DECISION DELEGATED TO HEAD OF PLANNING

Application No: H02-0197-25 **Applicant:** Mr & Mrs C Newman

Proposal: Details of gas/electricity external boxes, gas flues, soil vent pipes, proposed boundary treatments, existing and proposed site levels, proposed floor levels, hard surfaced areas, garden/amenity areas, foul and surface water disposal and Biodiversity Net Gain Plan (Conditions 4, 6, 8, 9 and 11 of H02-0266-24)

Location: Rear Of 1a Peterborough Road Crowland Peterborough

Drawing
Location Plan
Site Plan

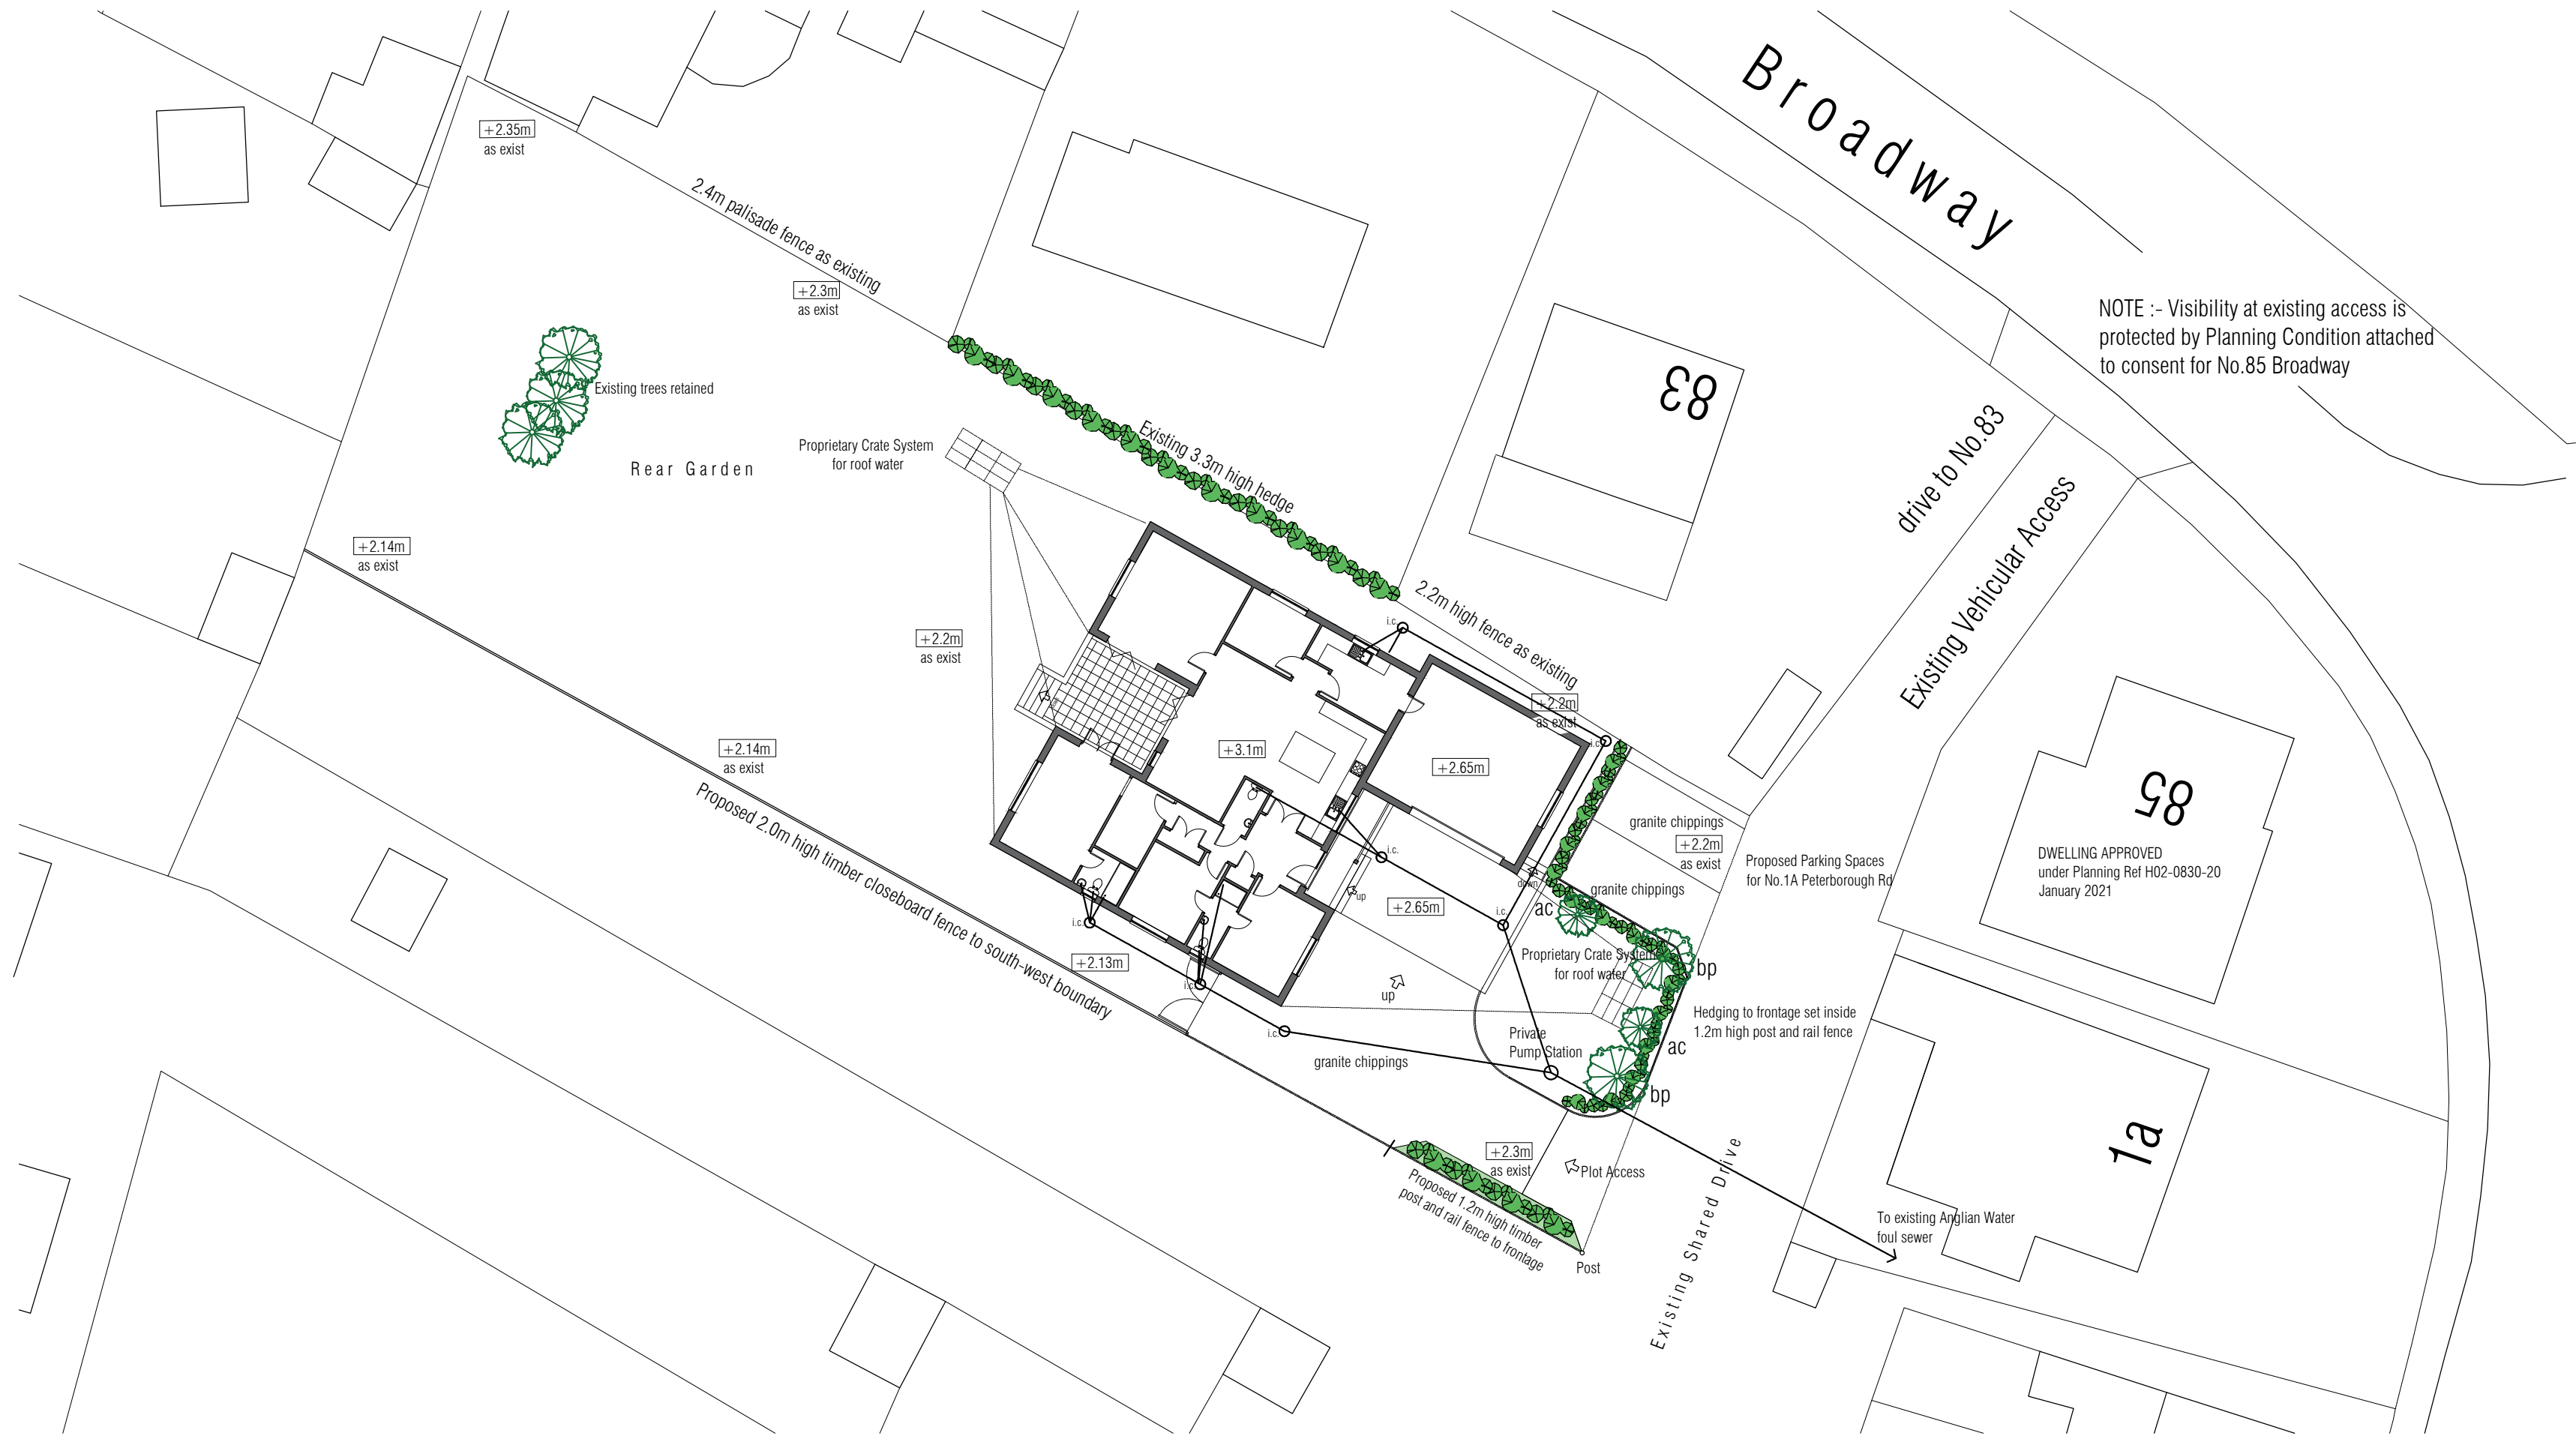
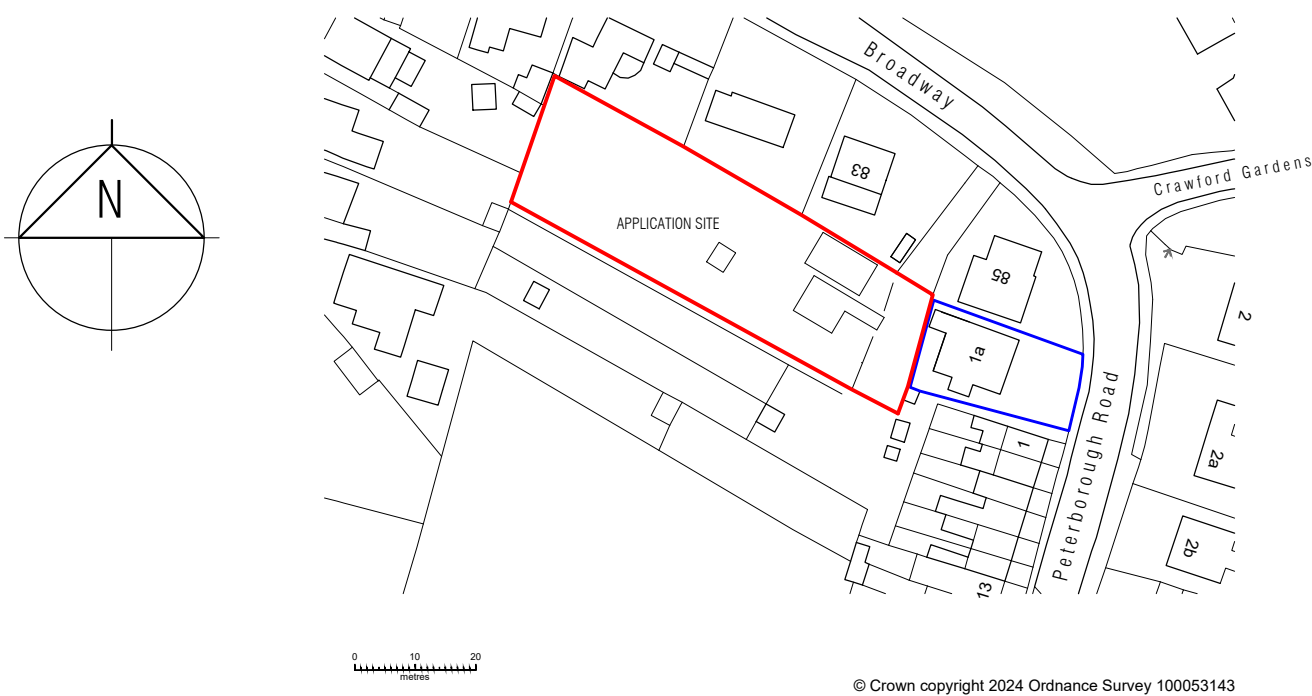
A 2-metre-high timber fence is proposed along the southwest boundary. A 1.2-metre-high timber post and rail fence is proposed to the front. A 1.8-metre-high fence will enclose the rear garden. All other boundary treatments shown are those currently in situ, including a 3.3 metre high hedge, 2.4 metre palisade fence, and 2.2 metre high fence along the north boundary.

The south facing windows measure from 1.6 metres (at the sill) to 3 metres at the head. Finished floor levels (as required by Condition 7) are set at 3.1 metre AOD, or approximately 0.8 metre above ground level. As such, a 2 metre high fence would be unable to prevent views into neighbouring properties. The land which would be overlooked does not appear to be used as traditional residential garden, instead appearing to have a similar use to an allotment. There are currently no treatments between plots. Therefore, the views gained here would not be overly intrusive, especially when considered in light of the existing conditions.

The vast majority of the existing boundary treatments appear to sit outside of the red line boundary for this site, including the 3.3 metre tall hedge. These treatments are essential to protect residential amenity, and to prevent views from the north facing study window. The treatments sufficiently ensure residential amenity is maintained. However, as these are located outside the red line boundary, and appear outside of the ownership of the site owner, their long term maintenance could not necessarily be ensured.

A note has been added to the site location plan, outlining that, in the event existing boundary treatments outside of the redline are removed, they are replaced with a 2.4 metre high treatment (comprised of a 2 metre high close boarded fence with 0.4 metre of trellis above). This is considered appropriate in light of the site constraints, preventing unnecessary fencing on the site while preserving residential amenity.

As such, the proposed treatments are considered acceptable. The provision of potential replacement fencing in the event of the loss of the existing treatments is considered appropriate given the circumstances of the site.

Cross - Section at narrowest distance between proposed bungalow and side boundary

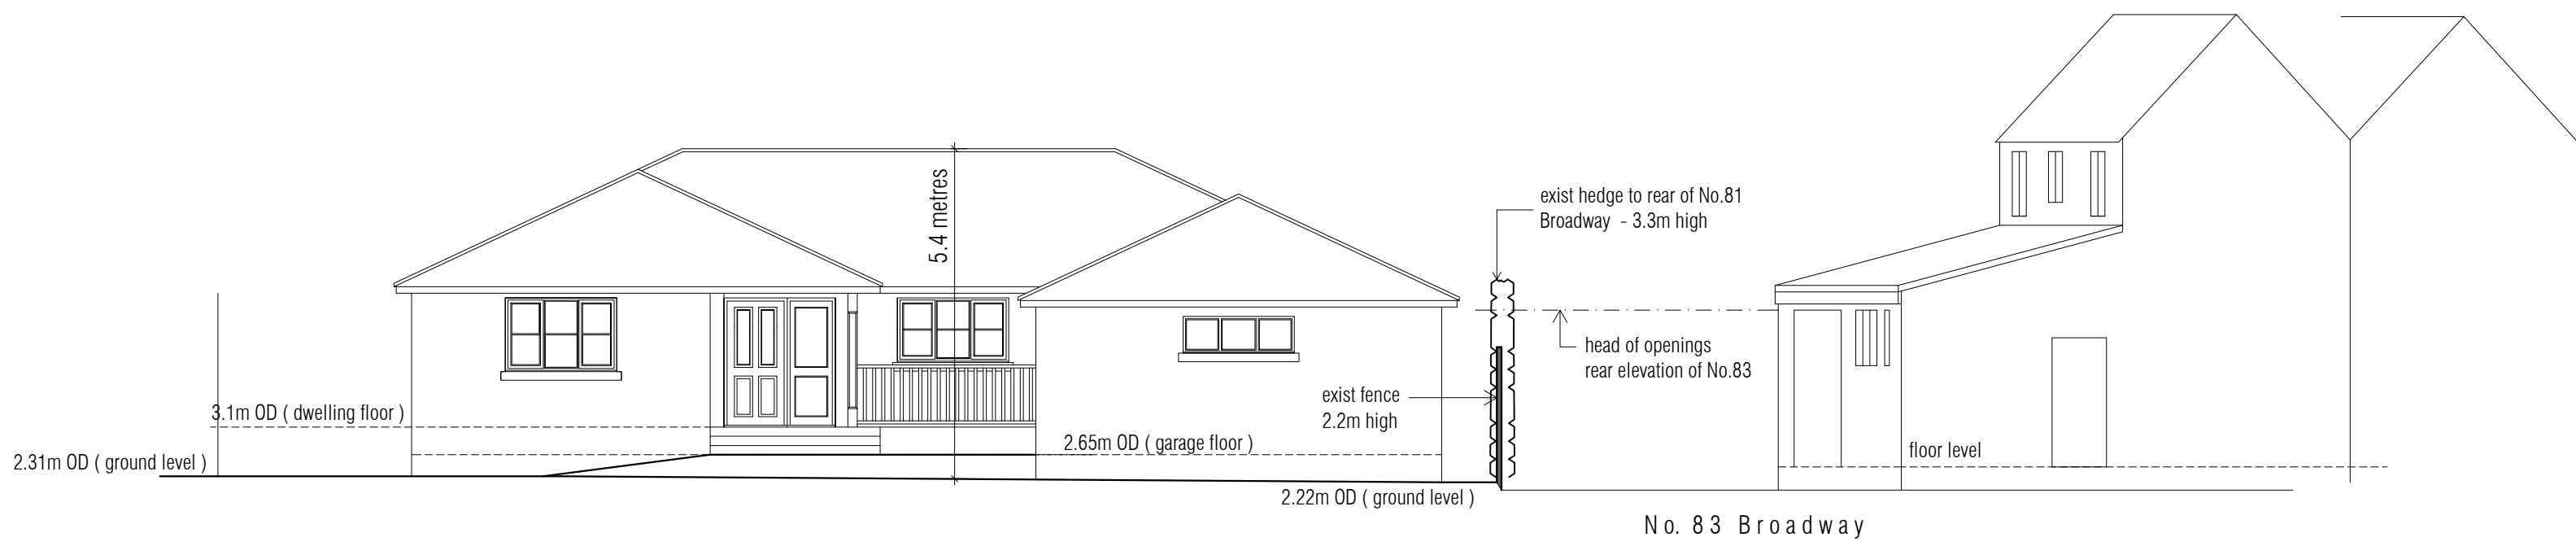
Condition 7 has required finished floor levels to be set no lower than 3.1 AOD, between 0.8 and 1 metre above ground level. The living space conforms to this, and is shown with suitable detail at the submitted cross sectional drawings.

The garage is set at 2.65 metres which, under the strictest interpretation of the wording of Condition 7, may be unacceptable; however, seeing as these are uninhabitable rooms, the levels are considered acceptable.

As such, the submitted details are considered to satisfy Condition 8.

north-east elevation (side)

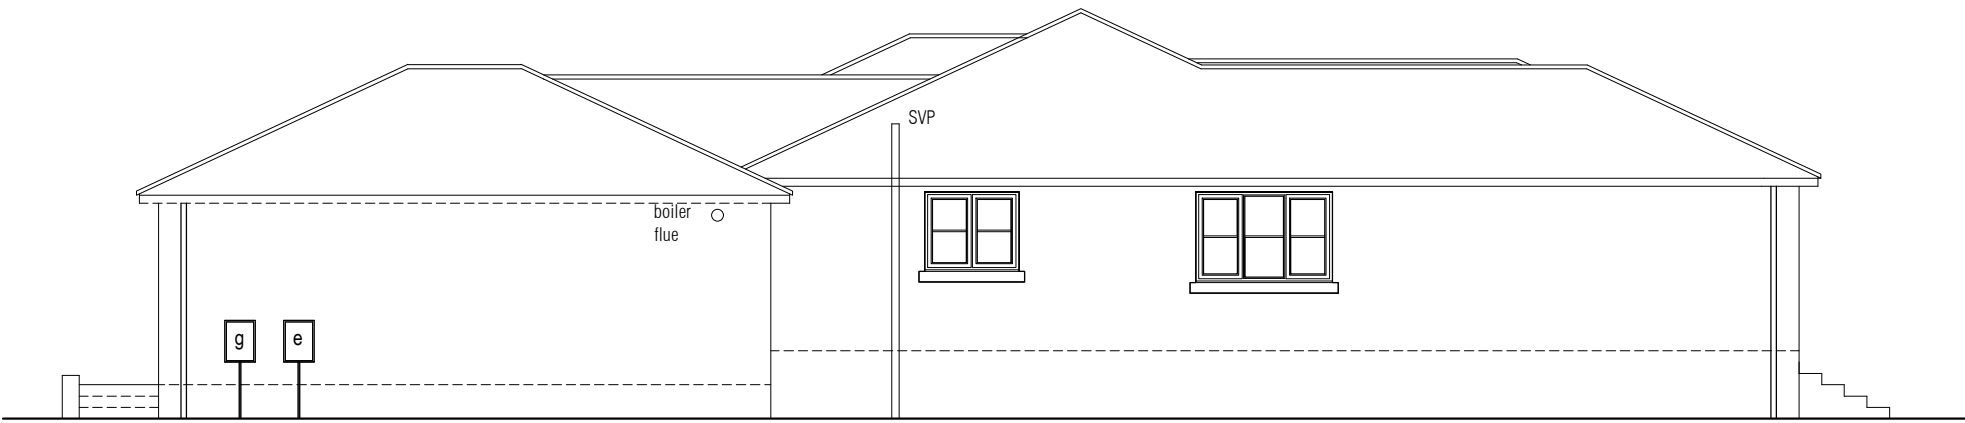
The details submitted show all domestic accoutrements located on the north-east elevation. No specific materials or detailed designs have been submitted. Despite this, due to the positioning of the development to the rear of existing dwellings, thereby reducing their visibility significantly, and the positioning to the side of the dwelling, it is considered further details are not required in this instance.

The positioning on the north-east elevation is considered acceptable, adequately restricting views of the equipment. As such, it is considered the requirements of Condition 4 has been satisfied and the condition can be discharged.
